Planning Application No: 3/2024/0185

Proposal: Planning permission for regularisation of change of use of first floor to tattoo studio and new external waste bin.

Location: 56 Moor Lane Clitheroe BB7 1AJ

1st Floor Room.

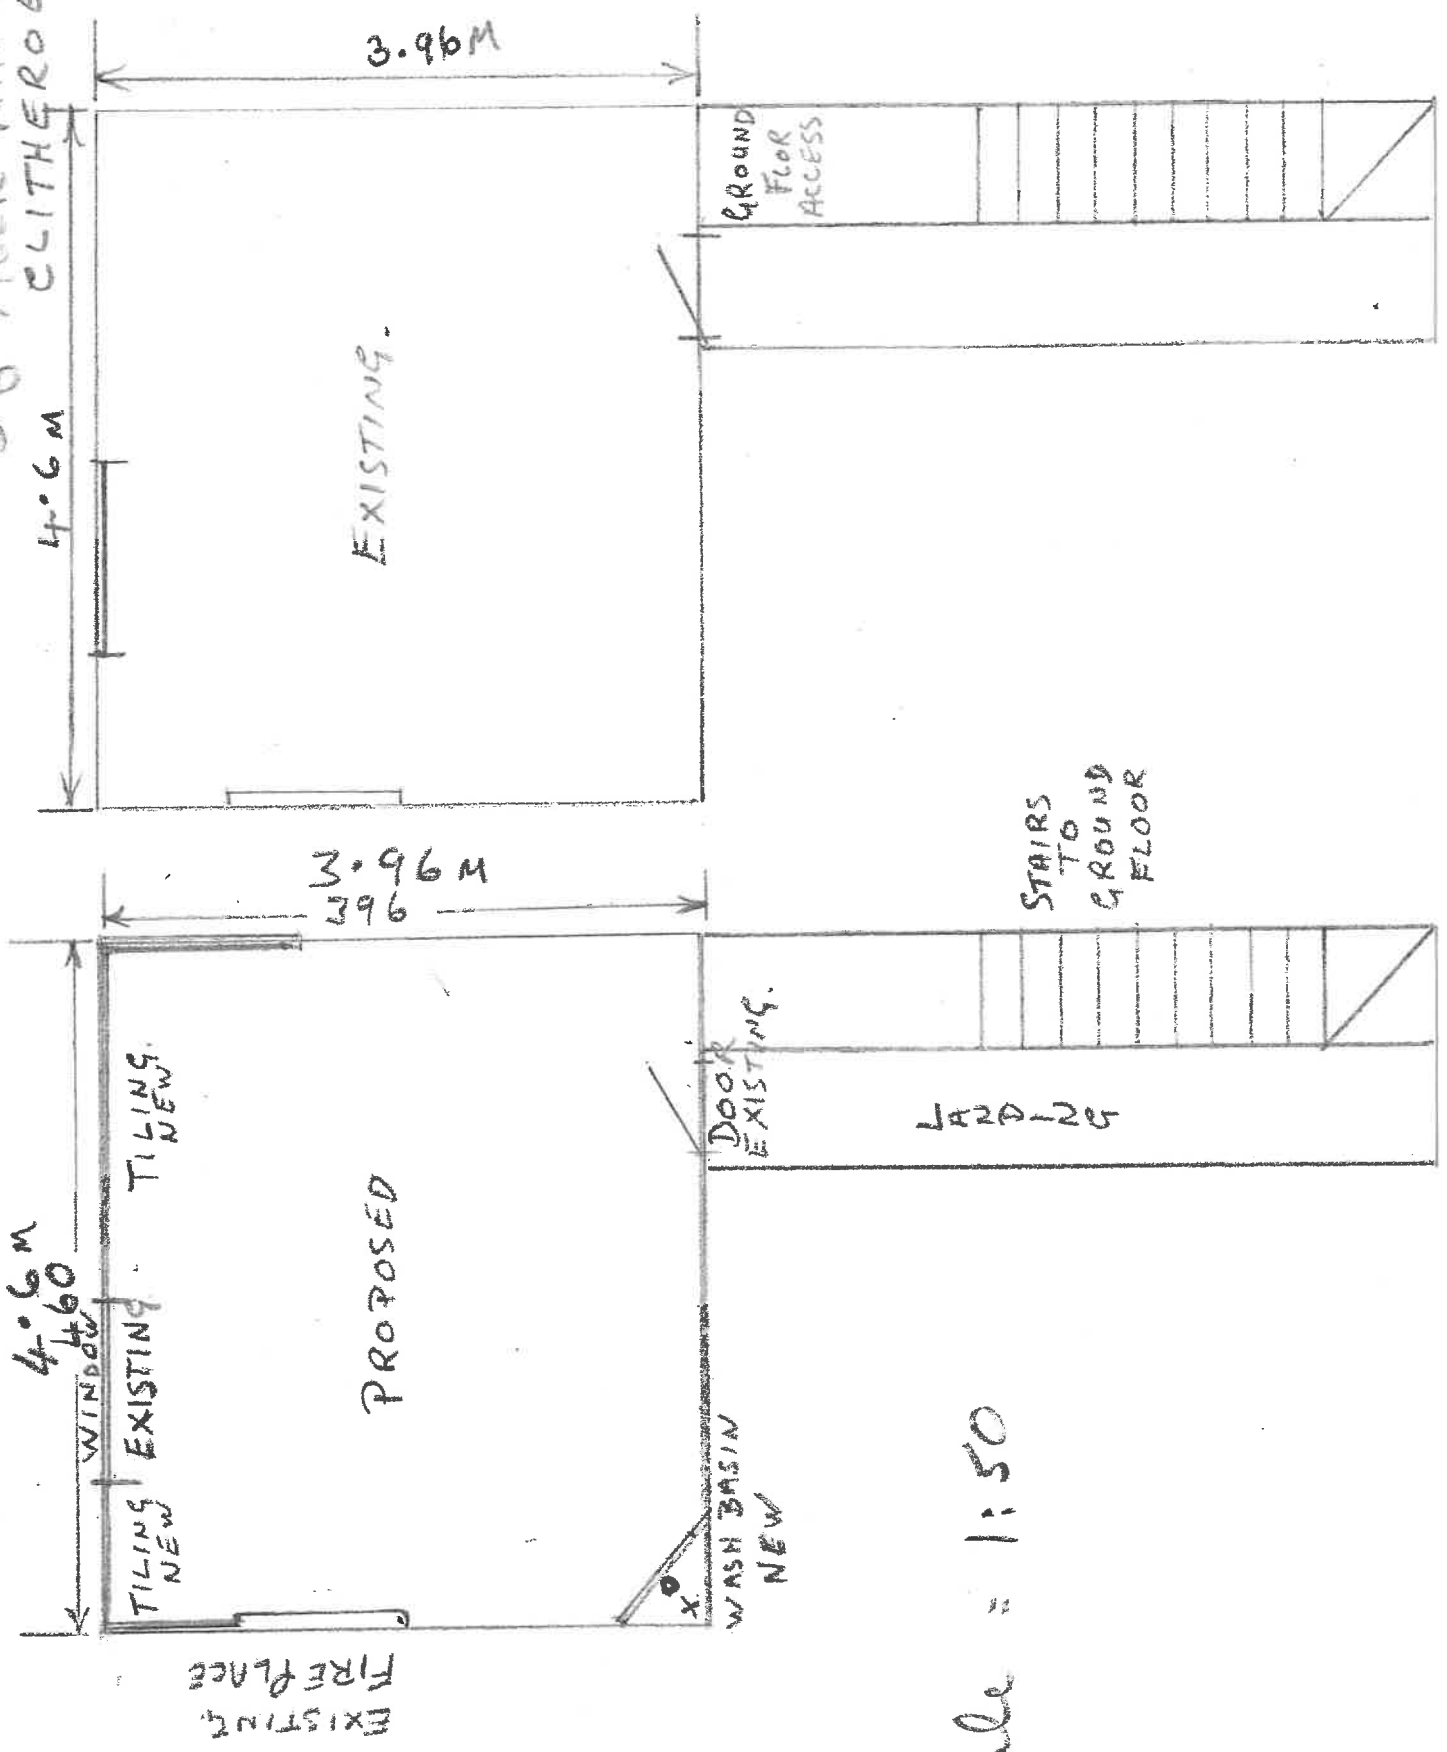
With reference to the Heritage Statement submitted, there is no objection to the proposal, however it should be noted the new external waste bin should be stored within the curtilage of the property, as proposed, in order to avoid refuse migrating and ultimately being left outside the property.
